1. We object the plans that have been submitted by the respective architect for the property in question. Existing plans do not correctly present the current floor plans of the existing rooms, including the naming/use of the rooms.

MRS GLORIA ROWLAND
Home Extension
391 St Albans Road West, Hatfield, AL10 9RU
Existing Gound, First
Second & Roof Plan

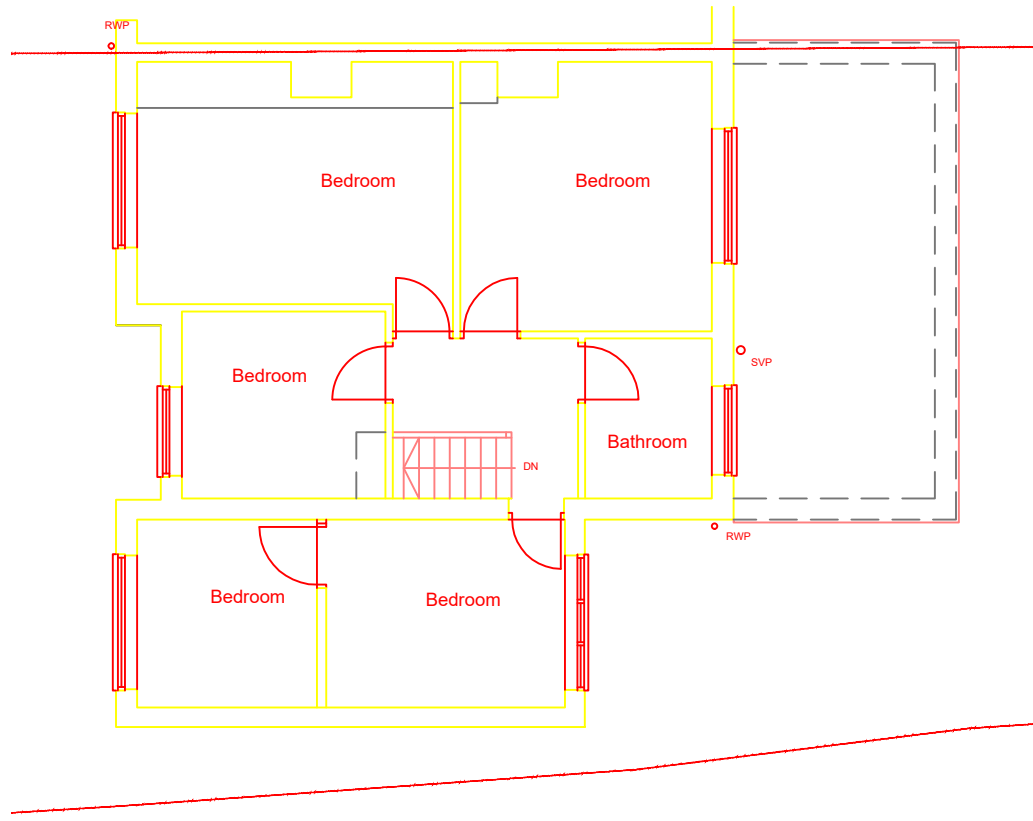
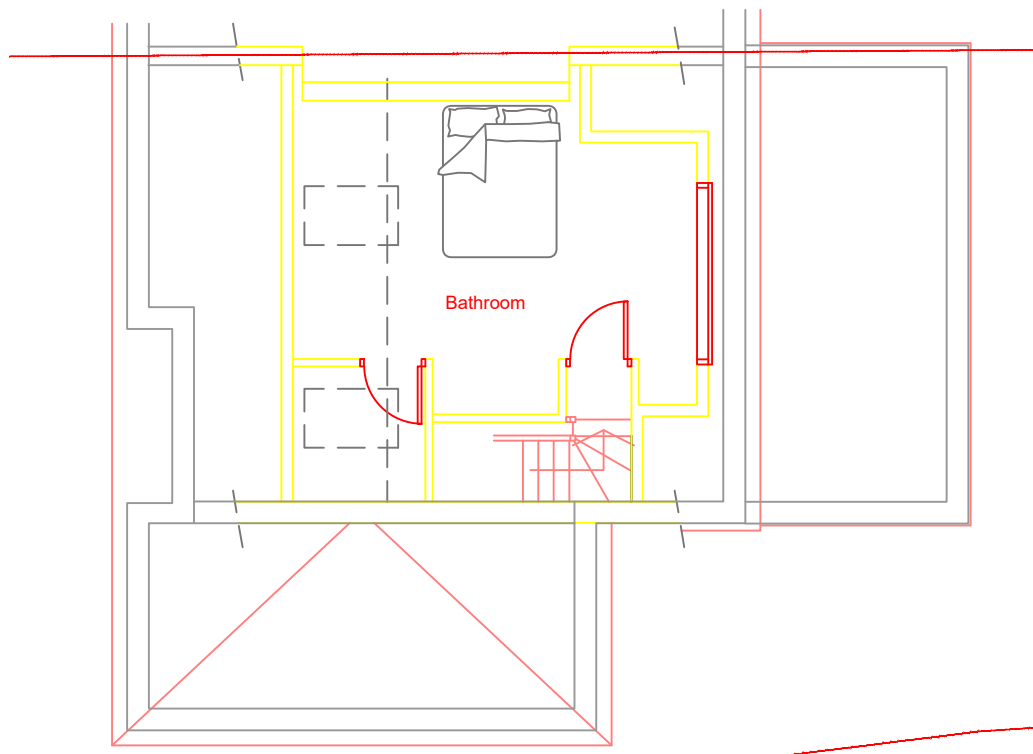
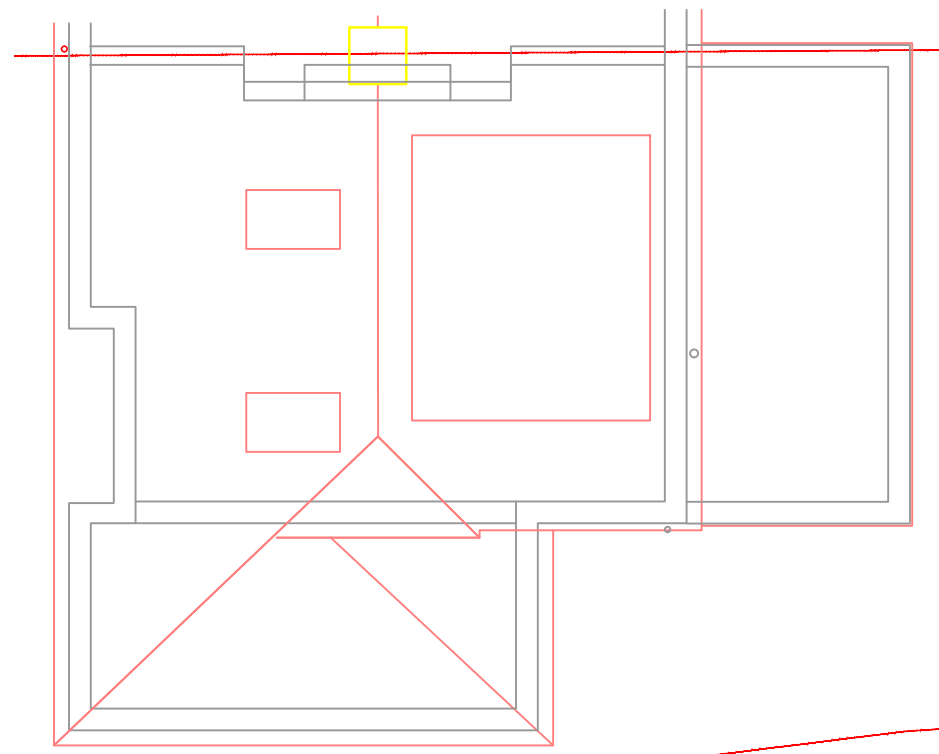
2. The plans have omitted to show the bedroom that is part of the current house- specifically located above the kitchen area facing the garden.

4. Dormer style extension does not exist as per plans showing it on the existing floor plans. The plans state that there are two sky windows at the front of the house roof, but they are not present on the current property.

MRS GLORIA ROWLAND
Home Extension
391 St Albans Road West, Hatfield, AL10 9RU
Proposed Gound, First & Roof Plan

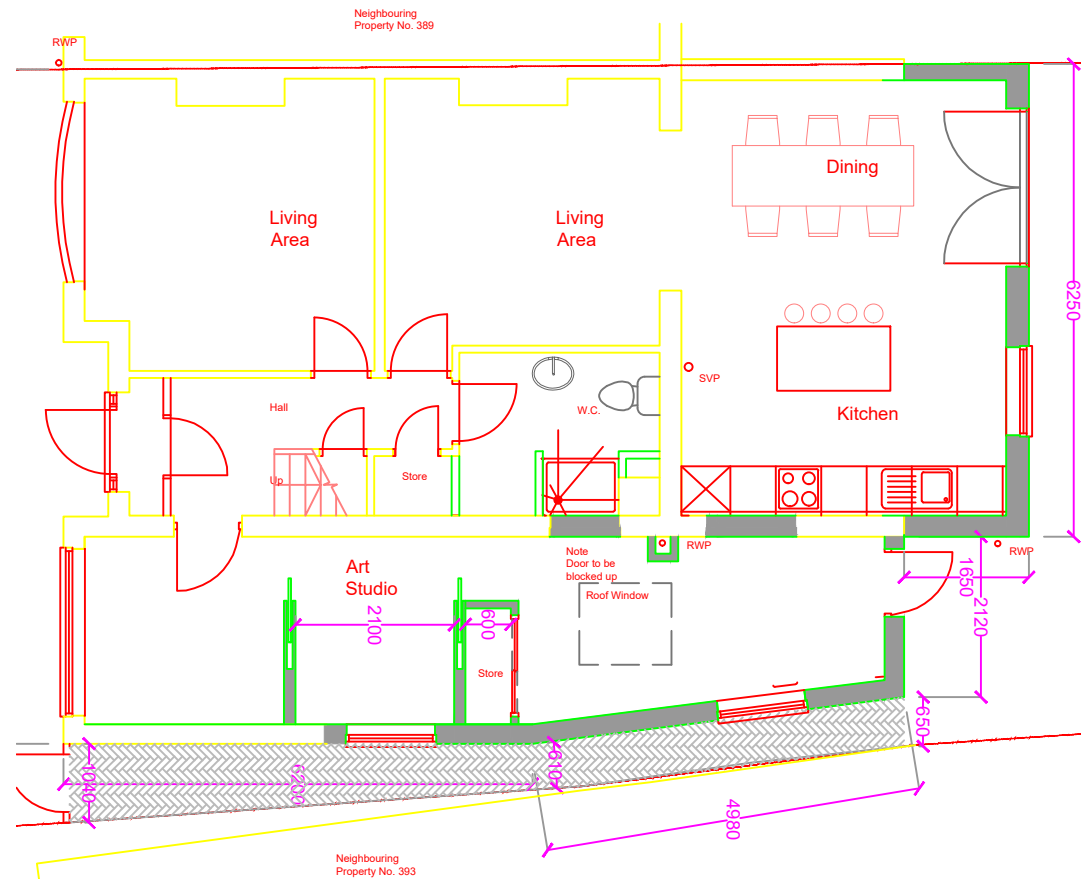
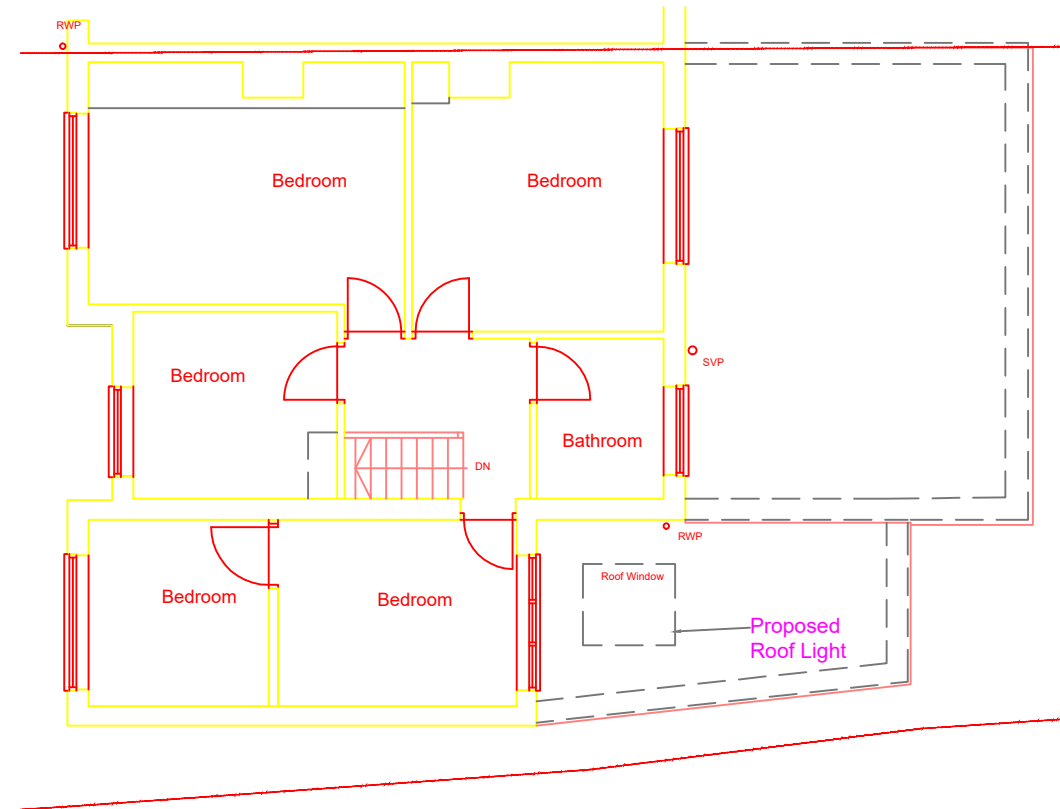
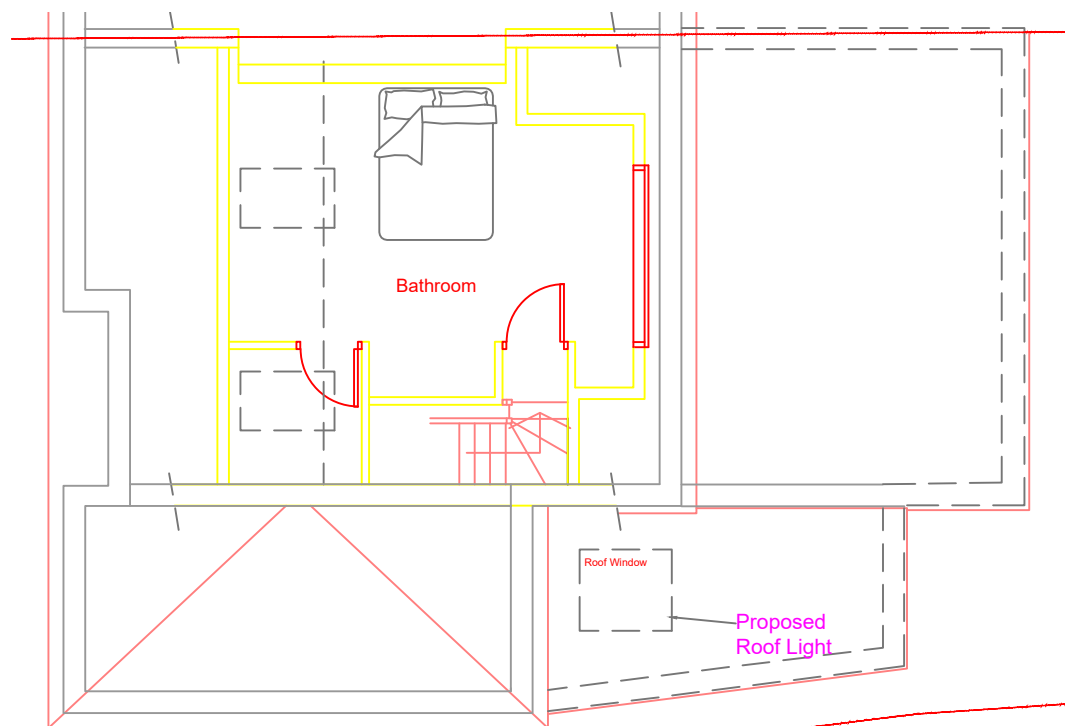
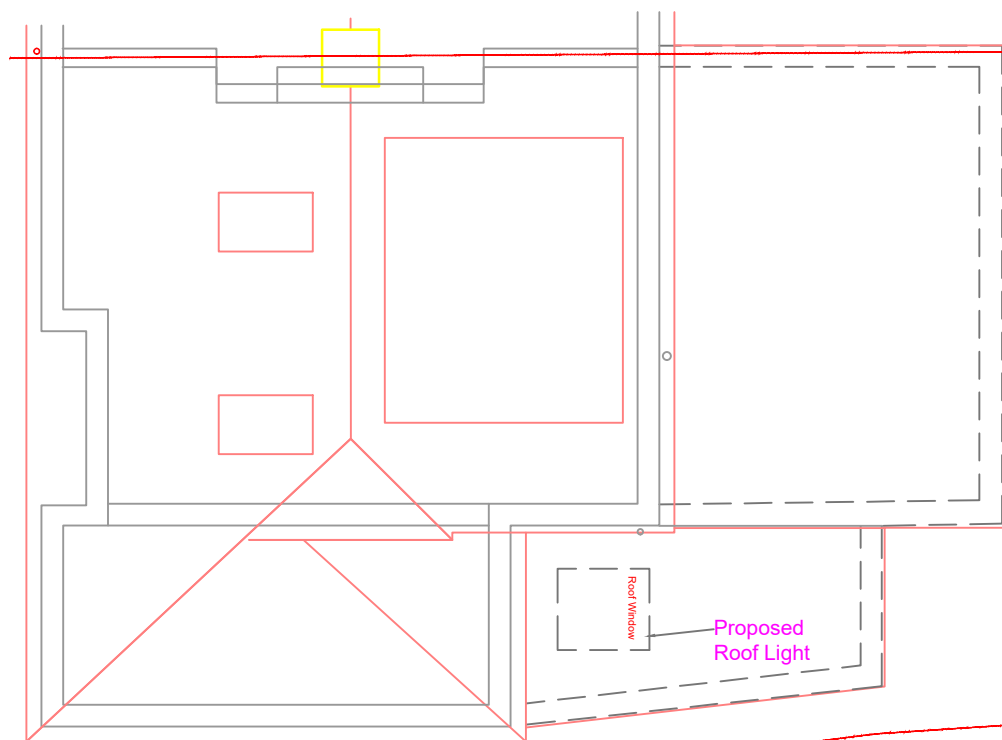
3. There is a large outbuilding (self-contained unit) approx. 7.5mx 4/5m in the garden is not showing as part of the present structures on the land even though it does show on the plans submitted by the previous owner in 2014, but in a way smaller proportion and size. Site plan only showing the outbuilding that is located at the end of the garden plot. Existing Unlawful Development: the large outbuilding at the immediate rear of the main residence is built over a public sewer and is used as habitable accommodation which does not follow the planning conditions given. Another important point to mention is that the outbuilding is so close to the main houses (including ours) that it in the case of a fire we would be unsafe, and it could cause severe damage and could easily spread to our property endangering our lives. Also extending the downstairs kitchen area leads to the house being directly connected with the outbuilding.

5. Parking is going to become an issue and there won't be enough parking spaces for the number of vehicles that the new house will need with the additional number of rooms. As of now the property has 3 parking spaces available.

We feel that the proposed size of the house and the added number of rooms is going to be way bigger than what the neighbouring properties have and done in the past. With that said the noise levels will go up.
